Recommendation Report for Consent to Display an Advertisement(s)

**REF NO:** BR/12/25/A

**LOCATION:** Land outside 24 London Road  
Bognor Regis  
PO21 1PY

**PROPOSAL:** Installation of 1 No. illuminated advertising display within communications kiosk with integrated defibrillator.

Elevations

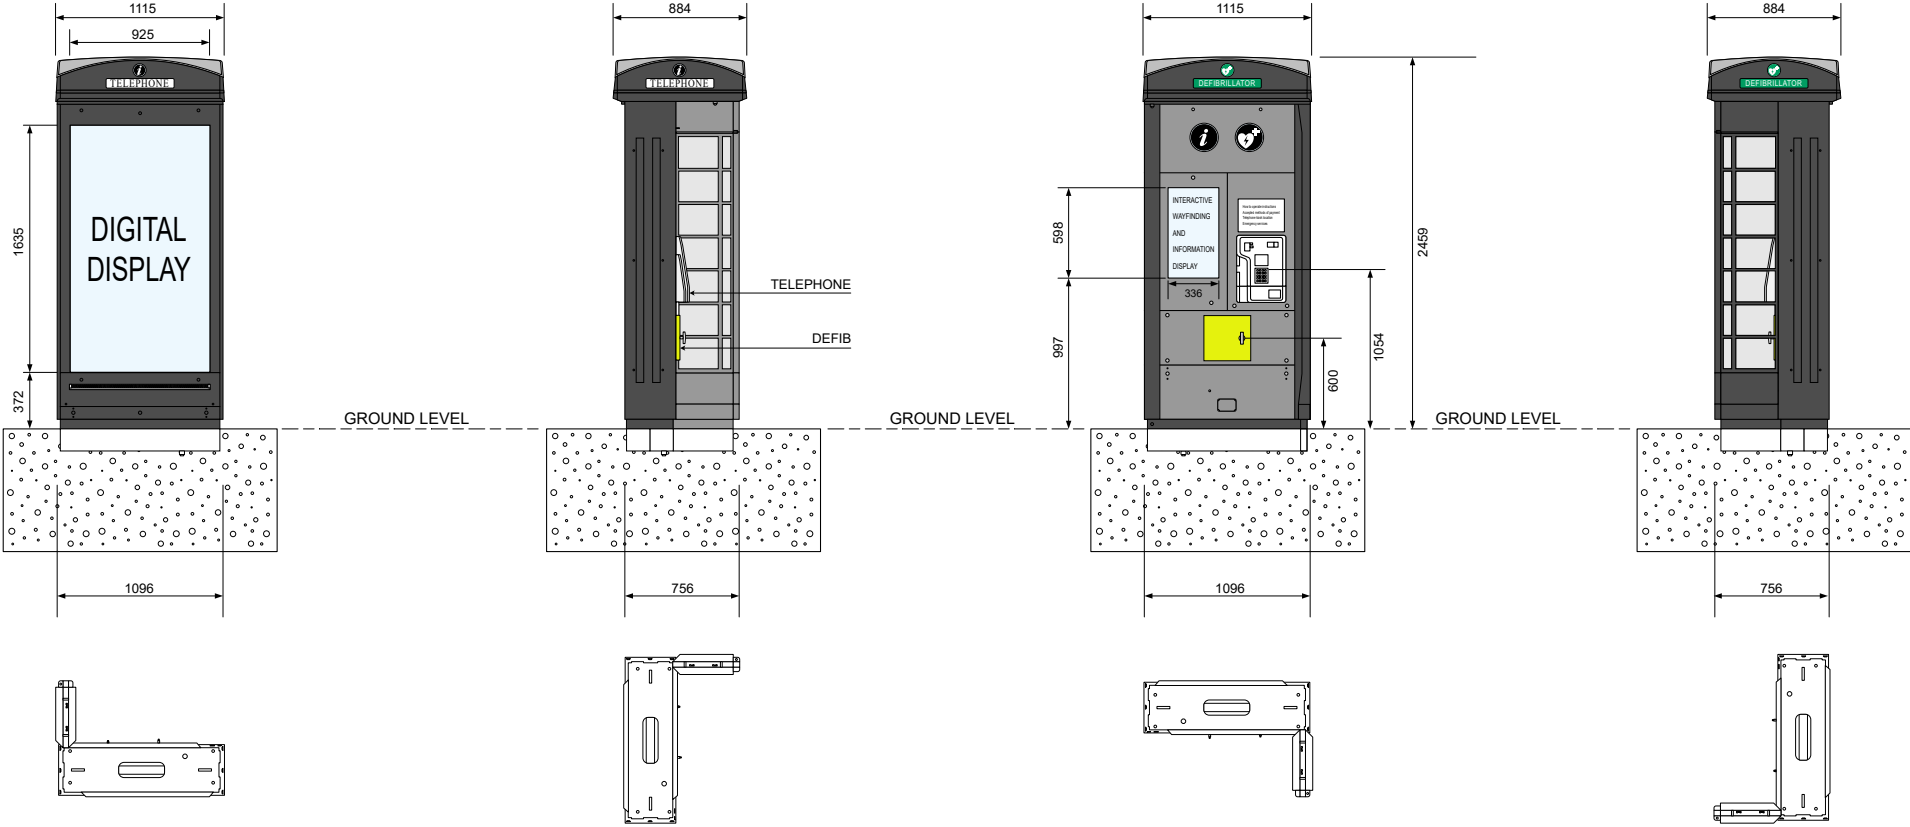
The kiosk with the integrated display is proposed in a retail area with advertising/hoardings on either sides of London Road. The LHA and Environmental Health Officer have recorded no objection to the proposal. Notwithstanding this, the display panel for advertising would appear prominent within the street scene, detracting from the existing shopfronts and would result in harm to the character of the area. It is noted that London Road is a retail area in which advertisements are not uncommon. However, there are no illuminated display signs present centrally along the length of London Road, therefore the addition of the kiosks with illuminated display would appear at odds with the wider character and appearance of the street scene.

The illuminated display screen on the proposed kiosk would be overbearing in the proposed location, drawing attention towards it and would result in demonstrable harm to the character of the locality and visual amenity of the street scene and wider area. The proposed development is therefore contrary to Paragraph 141 of the NPPF.

- 1 The proposed illuminated advertising display, by reason of its siting in the centre of the street would appear prominent, detracting from the existing shopfronts and it would appear at odds with the street scene. The proposal would result in demonstrable harm to the character of the locality and visual amenity of the street scene. The proposed development is therefore contrary to Paragraph 141 of the NPPF.
